Objection to Planning Application

Ref: Application 3/2021/0962/ 43 Hawthorne Place, Clitheroe.

PROPOSED FRONT ELEVATION SCALE 1:100

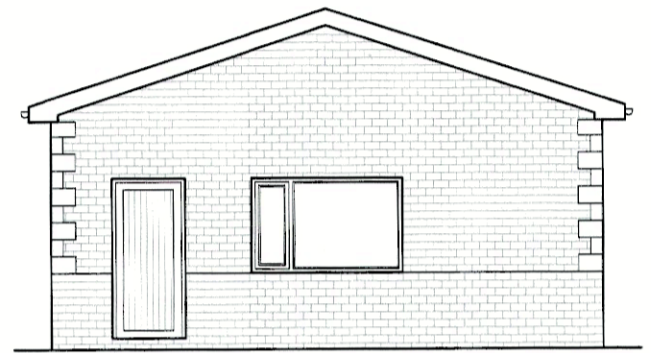
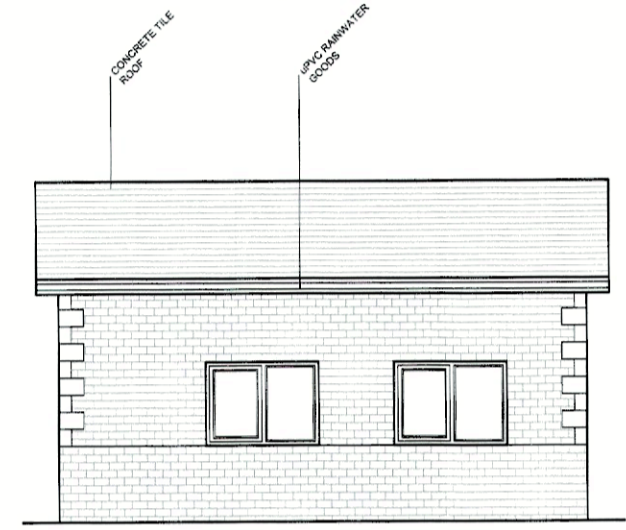
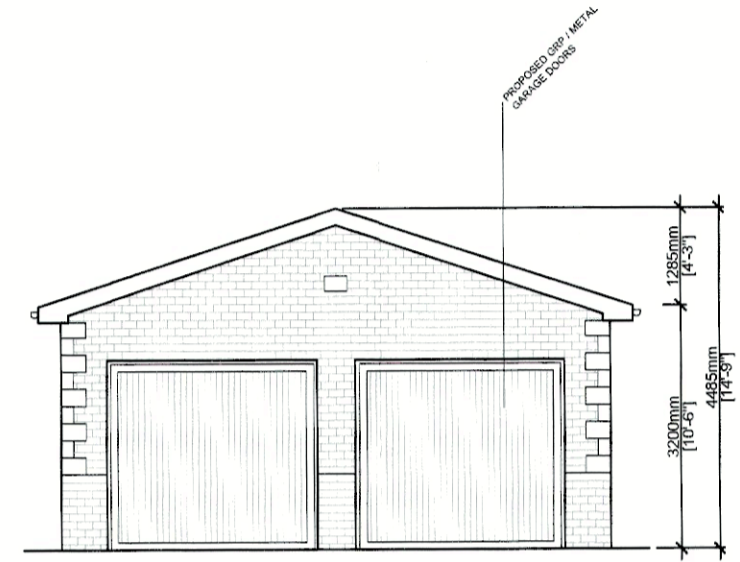
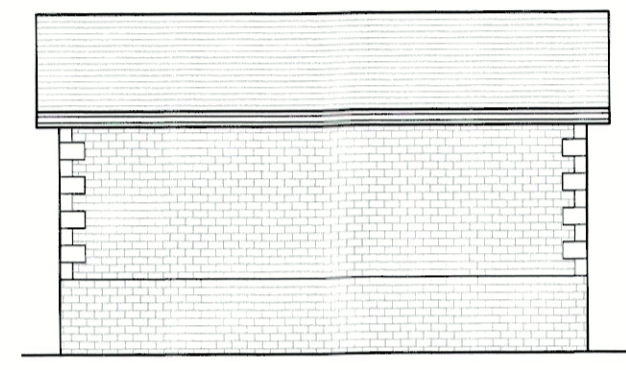
Firstly I would strongly advise that the planner carries out a site visit, as the drawing in the planning application do not clearly show the elevation changes on the site, which I believe are very important to any decision. I have no objection to a planner visiting my property if required.

- 1) Given the height and positioning of the building well above the ground

, it would be a dominating structure that would

be overbearing. As such the proposal would also cause harm to the living

- 2) [redacted] again based on the positioning of the garage [redacted] – the windows will be situated above the fence line, thus effecting the privacy

Blue line shows the dominating aspect of the garage and also demonstrates that the windows in the left hand side of the garage are above the fence line.

5) I also feel that the size of the garage (approx. 5mt metres tall) plus it's positioning to ground level, is oversized for a residential garage and not keeping with the street scene.

PROPOSED GARAGE FLOOR PLAN SCALE 1:100

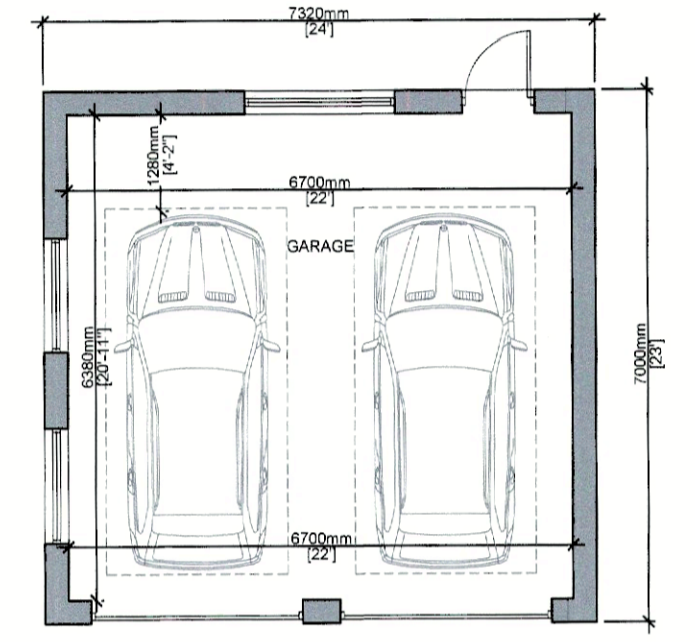
6.5 A further concern is the presence, within the proposed garage, of what appears to be a work area. [REDACTED]

PROPOSED SITE PLAN SCALE 1:200

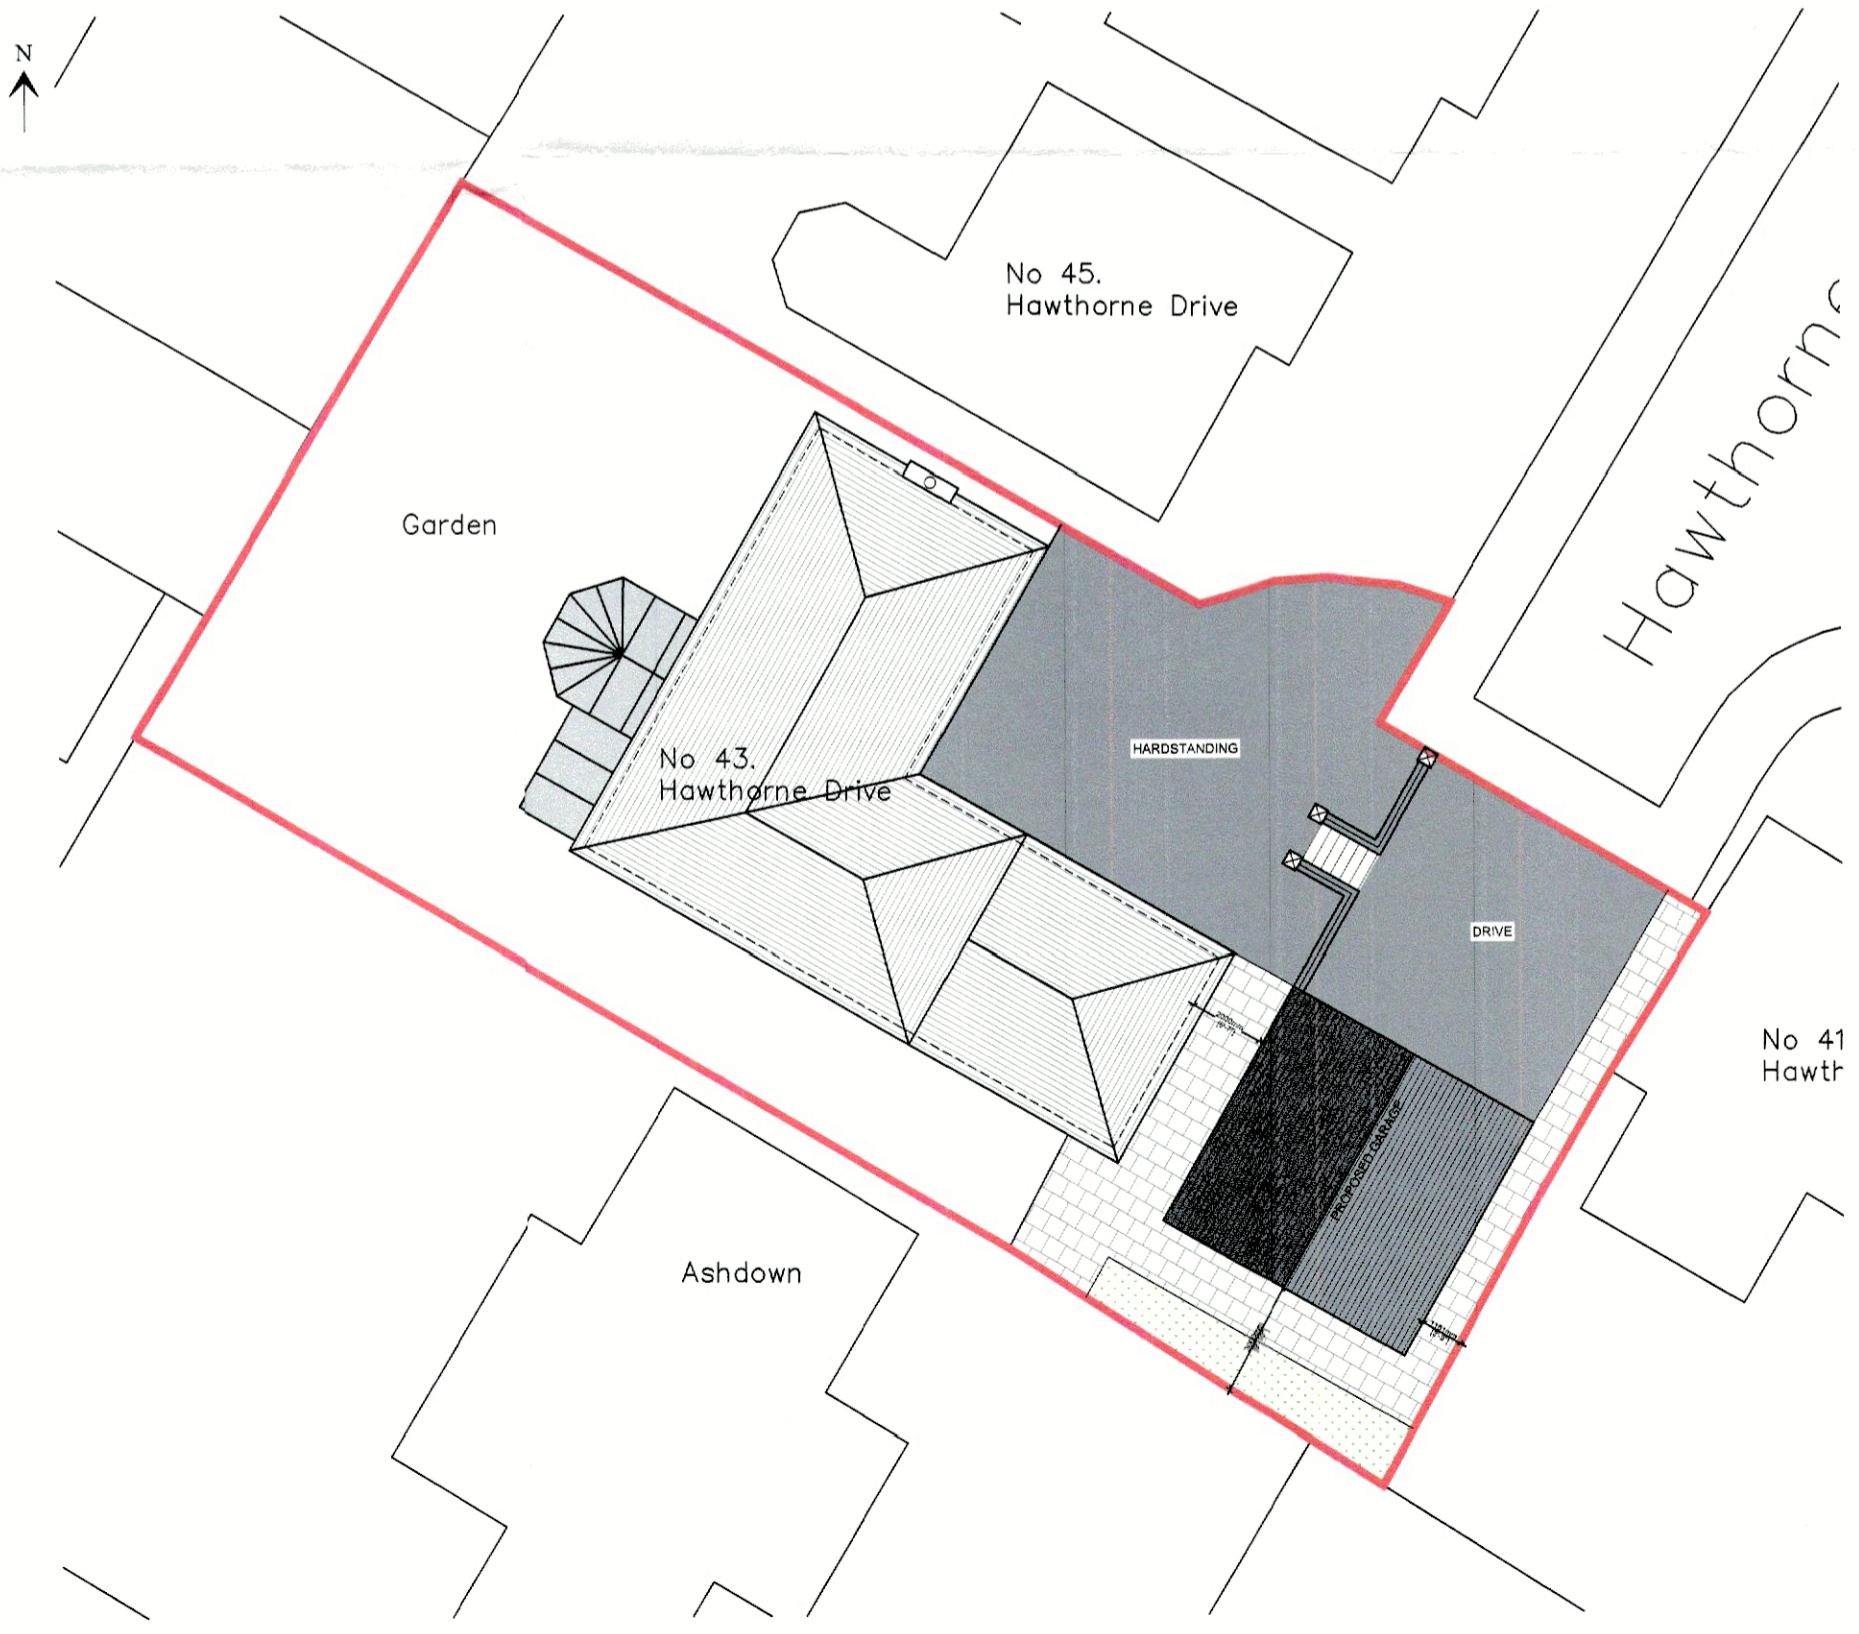
6.1 The proposed garage would be sited immediately adjacent to the boundaries with no.41 and Ashdown and will intrude and obstruct their space and light.

6.2 As with the previous Applications, the characteristic gaps between the buildings will be lost, and the garage building would appear as large, cramped and incongruous, and “an anomalous addition to the street scene”. Although the dimensions of the building in this Application are slightly less than the previous application for a garage and workshop (and less than the previous applications for houses), the reduction is marginal and the dimensions are still very significant, particularly in the context of this particular estate environment (and certainly one sought to be built in a tight space between established houses). In addition, if the Application were granted, the result would be that No.43 would have virtually no garden to the front in contrast to the pattern of development in the Close.
